Our Ref: NEW 17/107

**Development Application No. DA09/0701.03 Amendment to Development Consent DA 09/0701
for a 251 Lot Residential Subdivision (Department of Planning Application MP 09 0166, Mod 3)
at Fraser Drive and Parkes Lane, Terranora**

We refer to Tweed Shire Council submission dated 19 June 2019 and advise as follows:

PLAN SHOWING EXISTING TOPOGRAPHY
& PROPOSED SUBDIVISION LAYOUT

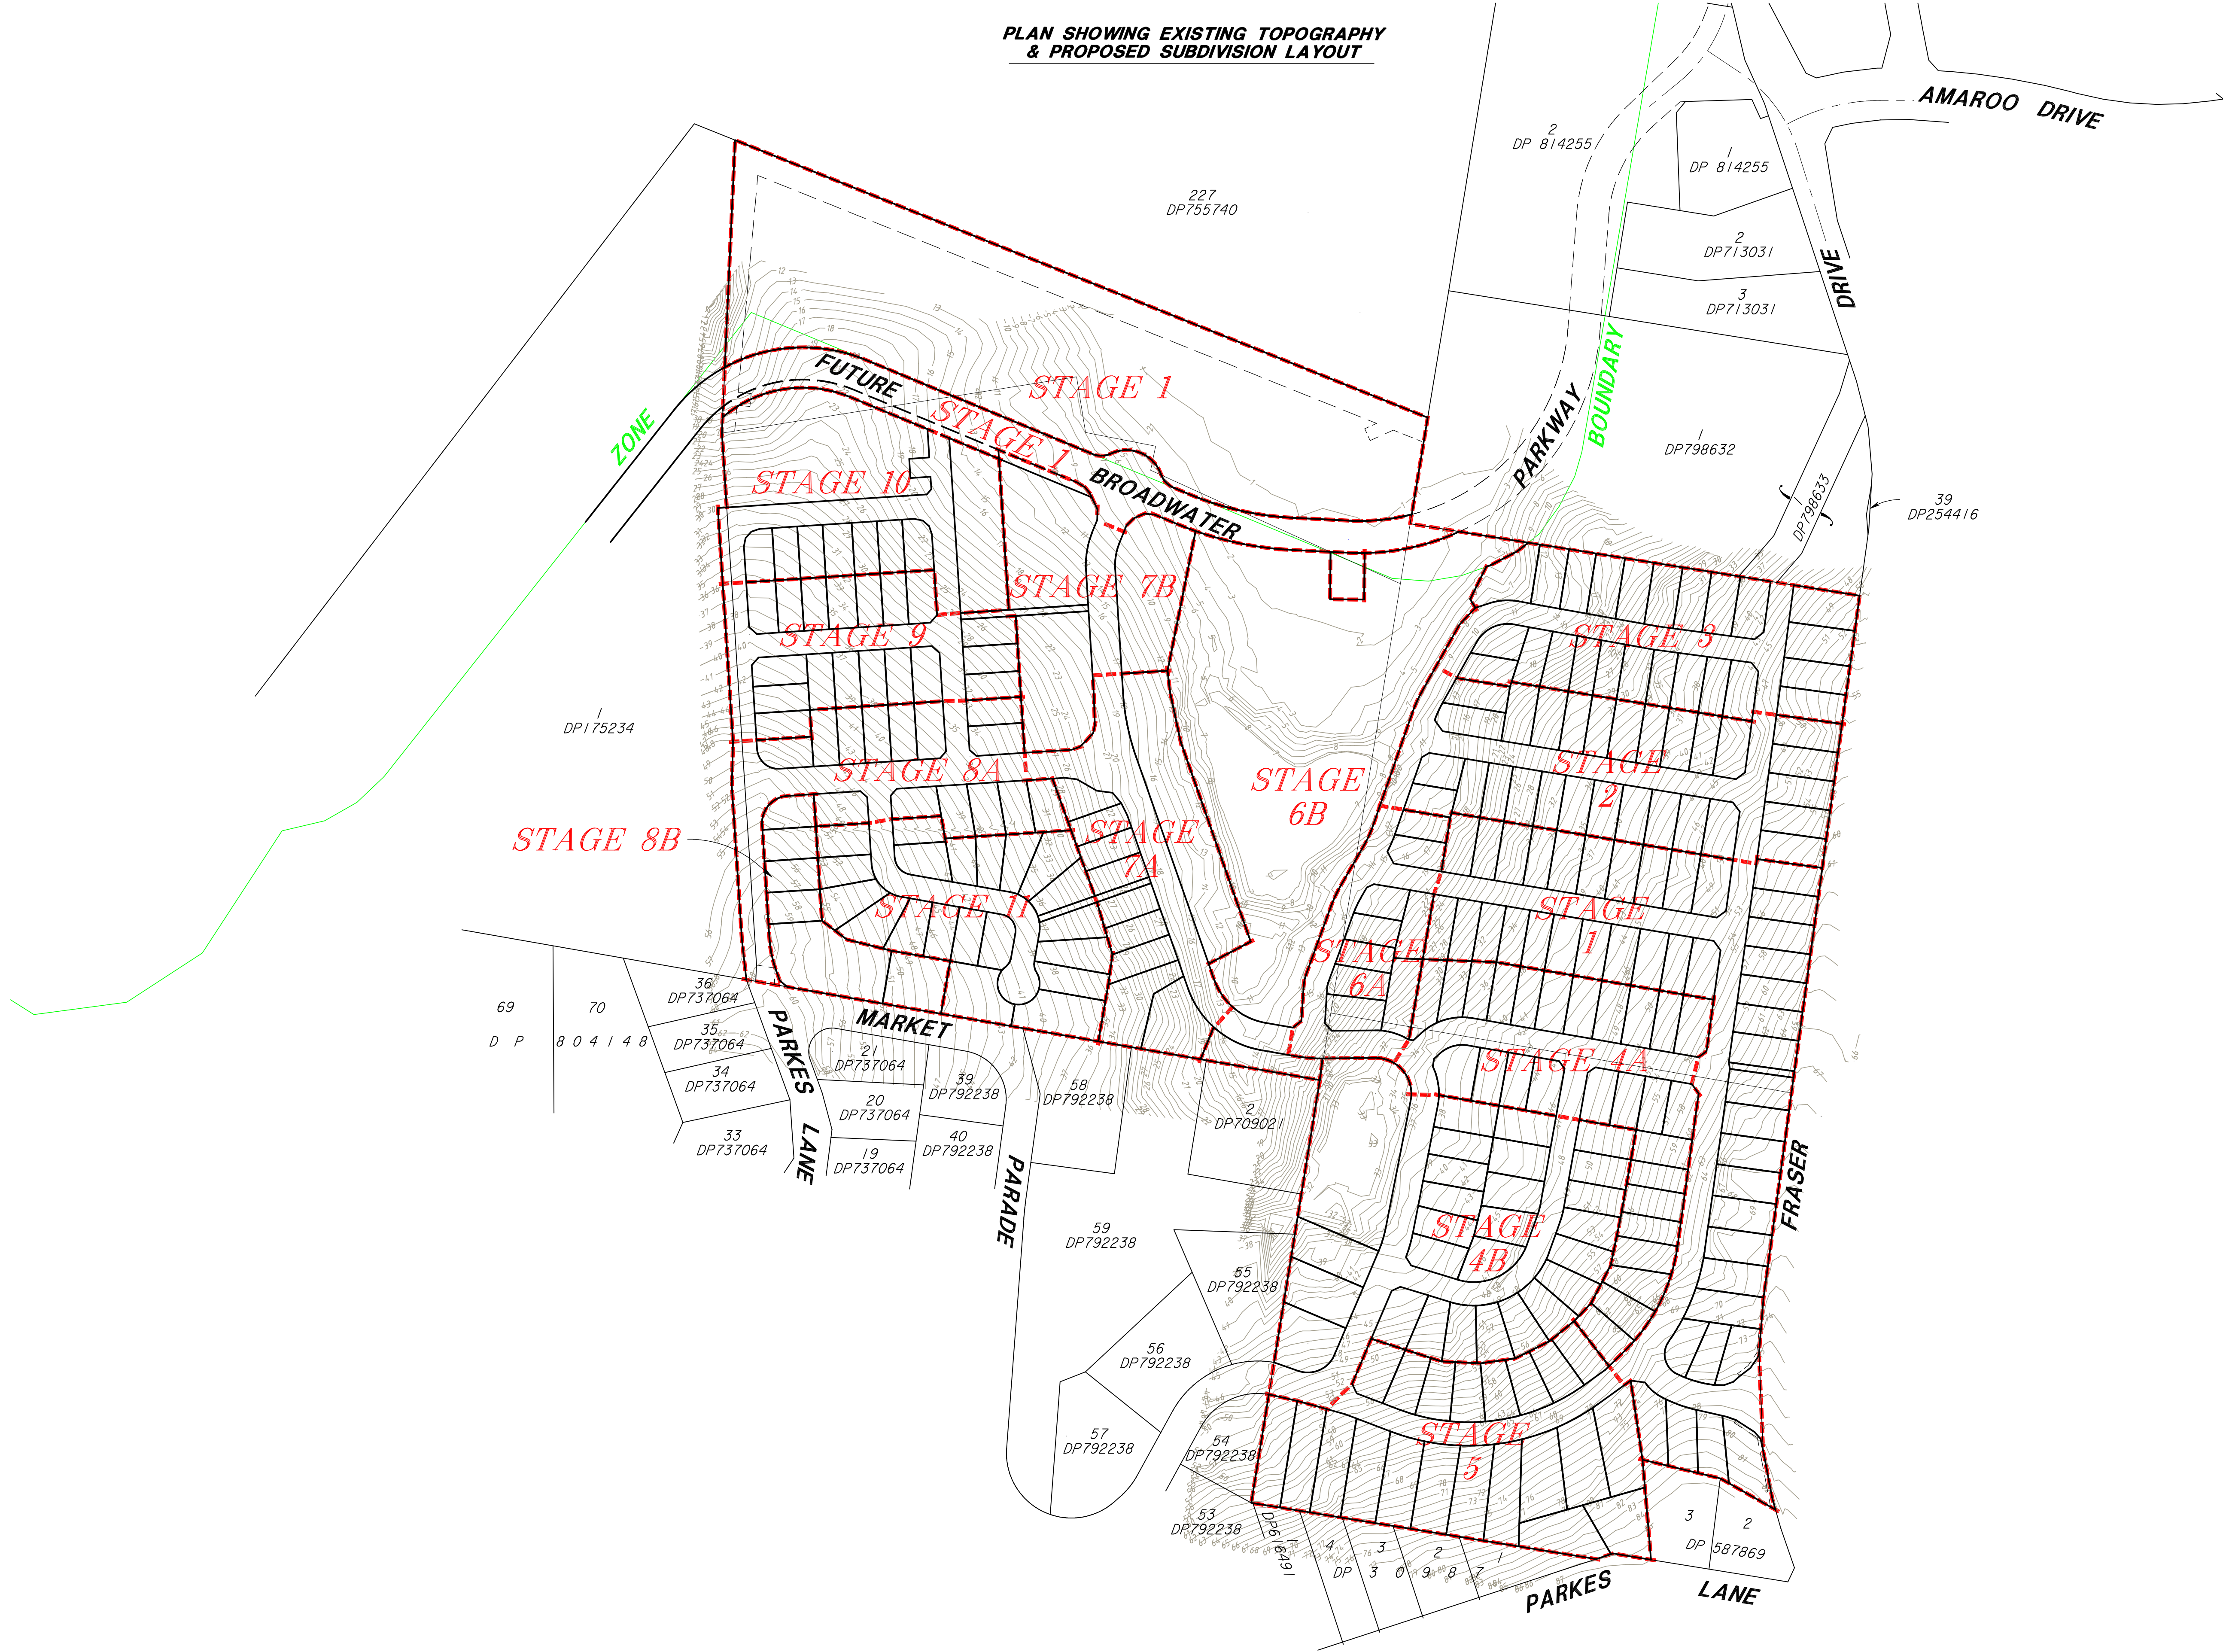
We agree that there are 15 stages. We also agree that Stage 4B comprises 26 residential lots (428 – 453).

We do not agree that Stage 8B comprises 4 residential lots. Lots 815 to 818 and Lot 820 result in a total of 5 residential lots (plus 1 public reserve Lot 819).

The project is to be constructed in **fifteen (15) stages**, generally in accordance with the 'Plan Showing Existing topography and Proposed Subdivision Layout' dated **13 March 2019**, prepared by B & P Surveys Revision **O** (Drawing No 18779B), incorporating the lots as follows:

- 8) Stage 8A comprises 14 residential lots 801 – 814 and incorporating roads and infrastructure;
Stage 8B comprises 5 residential lots 815 – 820 inclusive of public reserve on Lot 819 and incorporating roads and infrastructure;

SK 3617
REVISION H

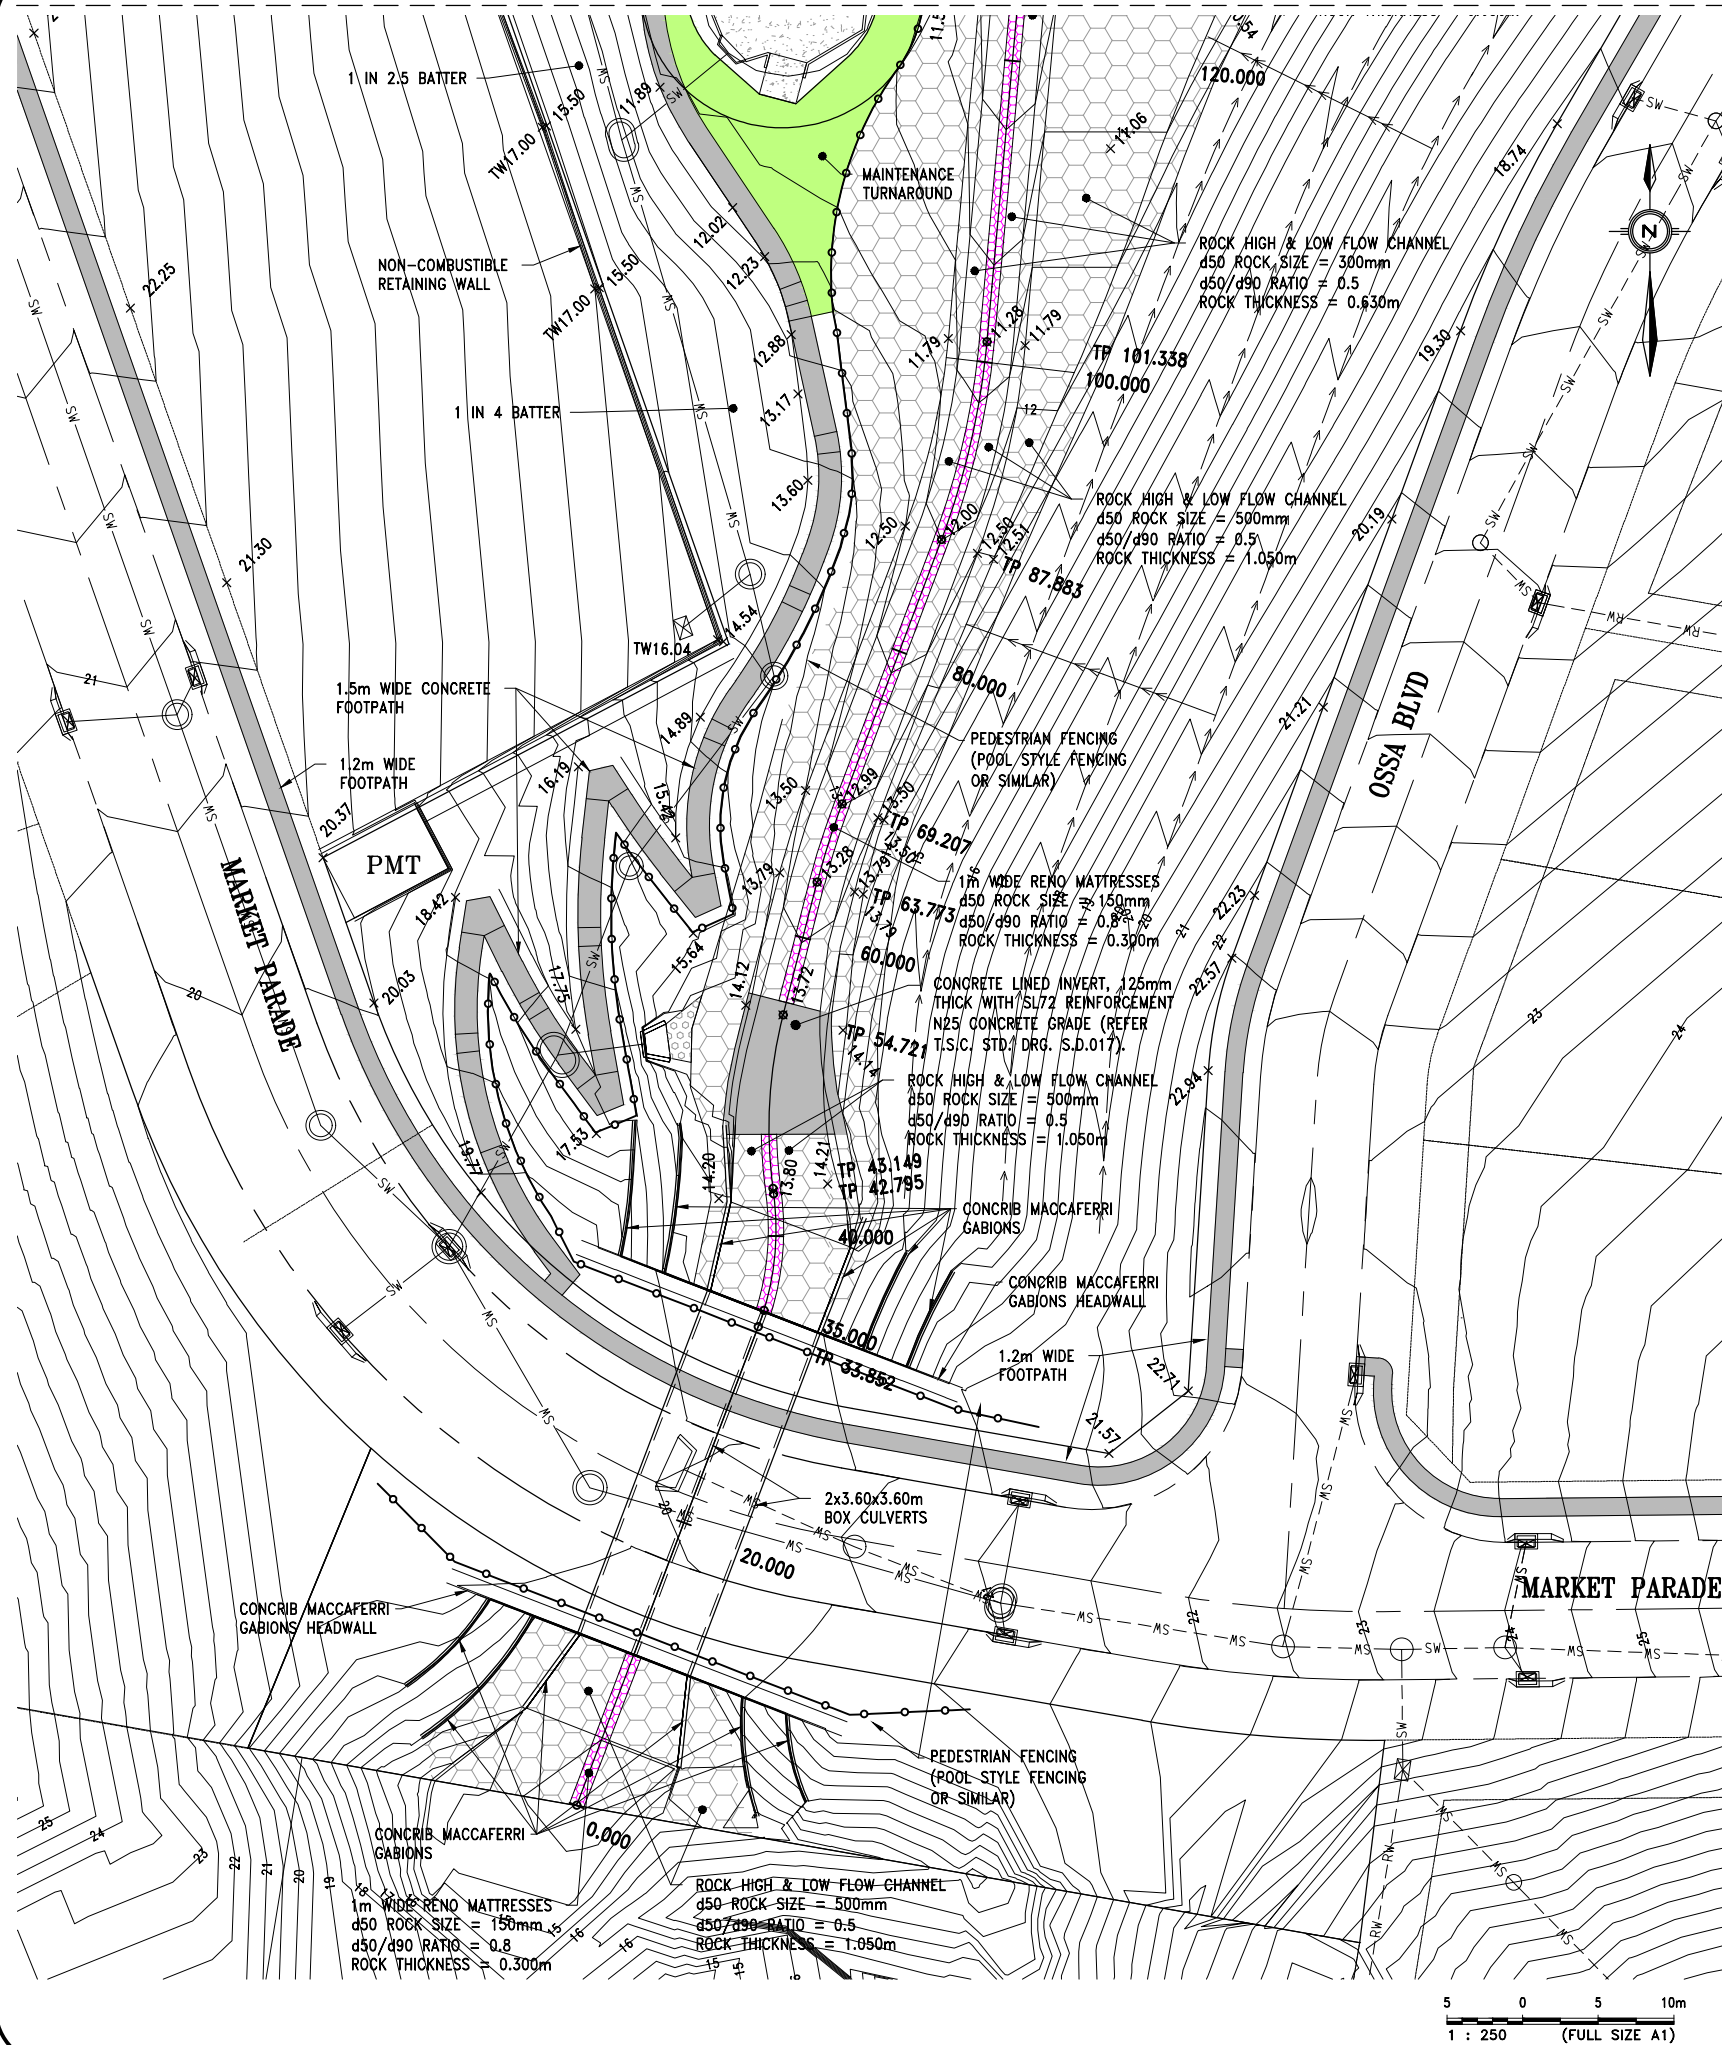
Condition A10 - Limits of Approval: due to the accepted inclusion of SK3617, this Condition also requires amendment as follows:

This approval also does not approve the construction of the proposed retaining walls proposed to create terraced lots in the eastern portion of the site bounded by Proposed Road No 8 to the north, Road 5 to the east, Road 1 and a small section of Road 2 in the south and Road 8 to the west, including any inter-allotment retaining walls to create terraced lots, as outlined on SK3617 'Retaining Wall Layout Plan' Revision H prepared by Bradlees Civil Consulting dated 26 May 2019.
